REPORT UPDATE

Application No: R/2/14/

LOCATION: 1 Merton Avenue
Rustington

PROPOSAL: Alteration of existing rear roof to form gable end and attic room with front velux type window

proposed rear elevation

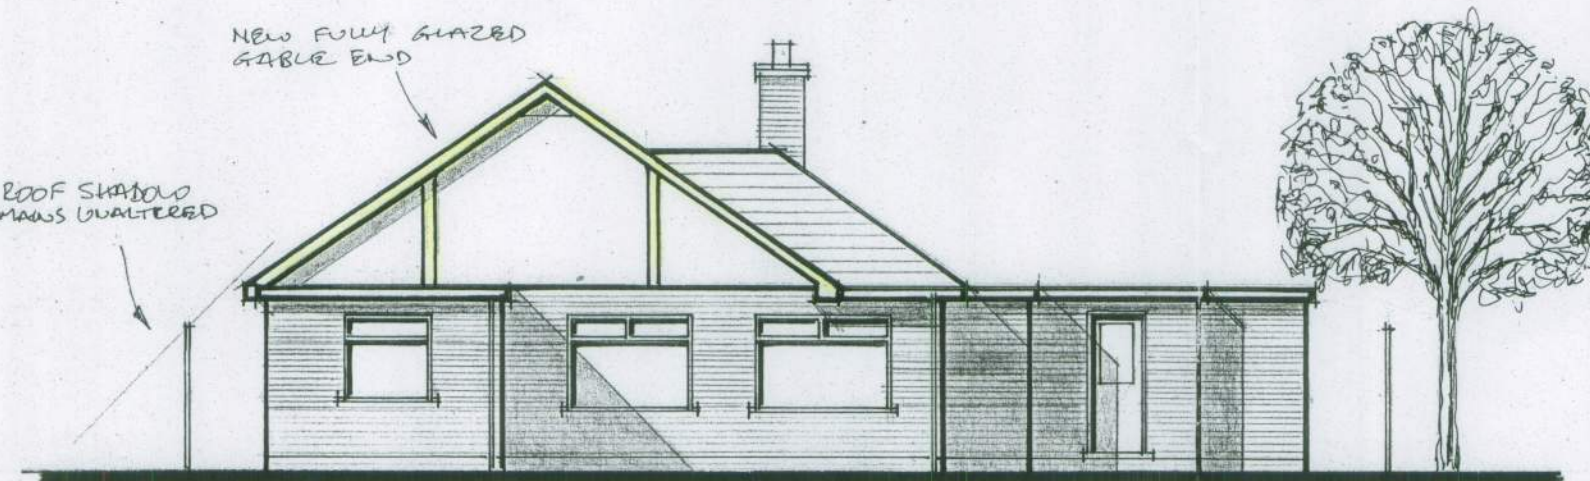
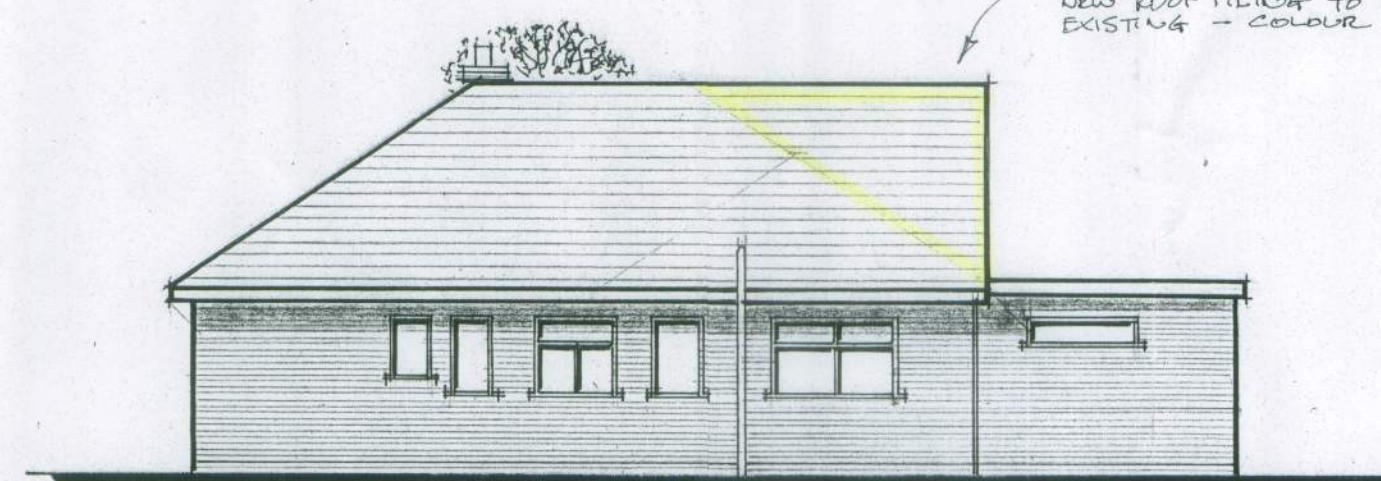
(i) The proposal for an attic room with a front velux type window would result in a loss of privacy for the adjacent properties, namely No. 5 Amberley Road and No. 3 Merton Avenue, by reason of overlooking to an unacceptable degree. This would most certainly adversely affect the peaceful enjoyment and amenities of the occupiers of the aforementioned properties.

- The fully glazed gable end will overlook the garden of No. 5 Amberley Road which will significantly impact on privacy.
- The drawings incorrectly show "existing tree screening" on the western boundary but these are in fact a trimmed hedge which does not provide adequate screening.
- The fully glazed gable end is not in-keeping with the architecture of nearby properties. It is unsympathetic and incongruous in its design and scale to the house.
- Allowing this extension would set an unfortunate precedent for any subsequent proposals in Rustington.
- Light pollution from the gable end would impact No.5 Amberley Road and other neighbours.
- The plans are incomplete as there is no drawing of the existing and proposed side west elevation.

The roof will be extended to the rear and face northwards to a well screened garden. This means that any overlooking on to neighbouring properties and gardens will not be direct and so is regarded as being acceptable. No windows are being proposed on the sides of the roof extension (east and west) which prevents overlooking in these directions and the neighbouring properties of No. 3 Merton Avenue and No. 5 Amberley Road respectively. However, it is recommended that a condition be placed on the permission to ensure that no windows or other means of opening be inserted into these roofslopes without a planning application first being submitted on that behalf.

The glazed gable end is not considered to cause harmful light pollution due to the adequate separation distance being retained between this and neighbouring properties to the west (a minimum of approximately 13m) and the fact that the extension serves a residential property. The roof extension is also not expected to have an unacceptable overbearing or overshadowing effect on No. 3 Merton Avenue due to a roof pitch which significantly slopes away from the eastern boundary and an acceptable separation distance measuring approximately 1.4m.
